**From:** [Borough Planning](#)  
**To:** ["sterling@strataarchitecture.com"](mailto:sterling@strataarchitecture.com)  
**Subject:** FW: 23/00599/A | 78 Old Hunstanton Road Signage | FAO Lesley Raby - Invalid Letter  
**Date:** 16 May 2023 14:34:45  
**Attachments:** [image003.png](#)  
[image004.png](#)  
[image005.png](#)  
[image006.png](#)  
[image008.png](#)  
[661 - Signage Details Example.png](#)

**From:** Sterling Sewter <[sterling@strataarchitecture.com](mailto:sterling@strataarchitecture.com)>  
**Sent:** 10 May 2023 11:14  
**To:** Borough Planning <[borough.planning@West-Norfolk.gov.uk](mailto:borough.planning@West-Norfolk.gov.uk)>  
**Subject:** 23/00599/A | 78 Old Hunstanton Road Signage | FAO Lesley Raby - Invalid Letter

Signage  
Site Plan

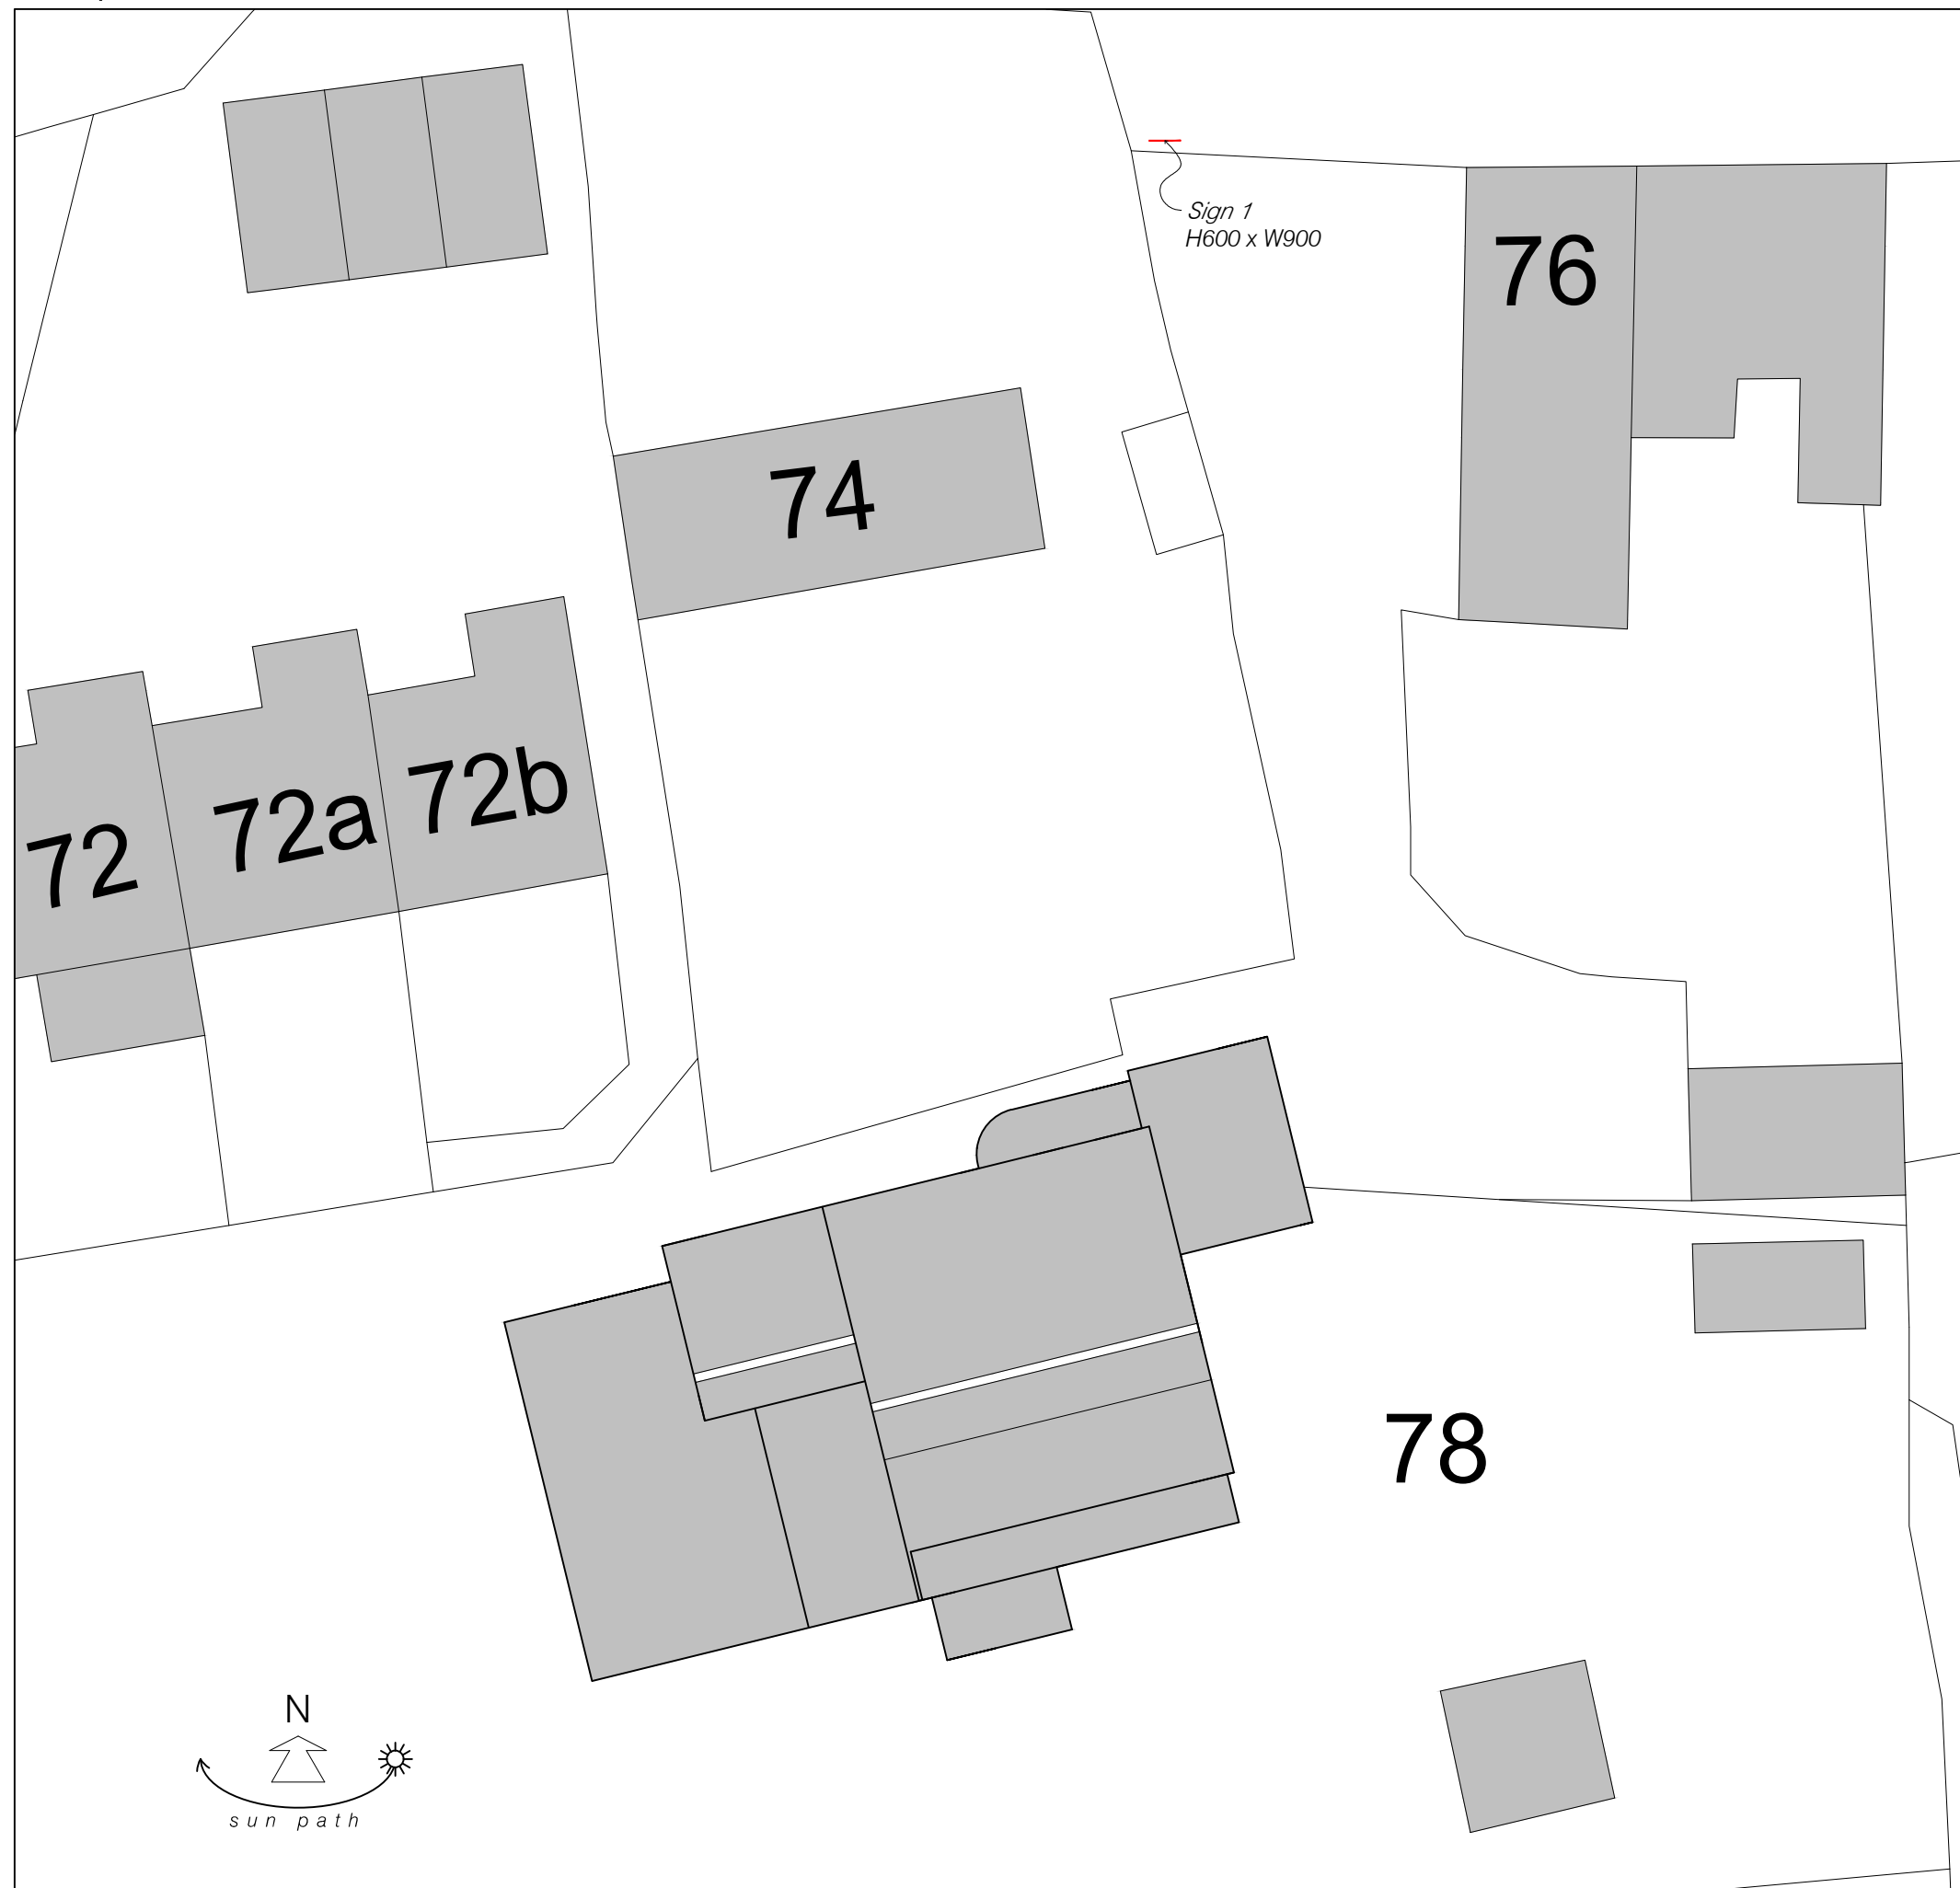
If sign two is not applicable to this application, you will need to remove all reference to it on the plans, or it will cause confusion for consultees and members of the public.

Please send through amended plan referring only to the sign relating to this application.

1. The location plan has been sent on the previous email - I've attached just in case.
2. Yes that is correct, there is only going to be one sign on this application due to the site layout. Please ignore 'sign 2' on Plan 452-02.
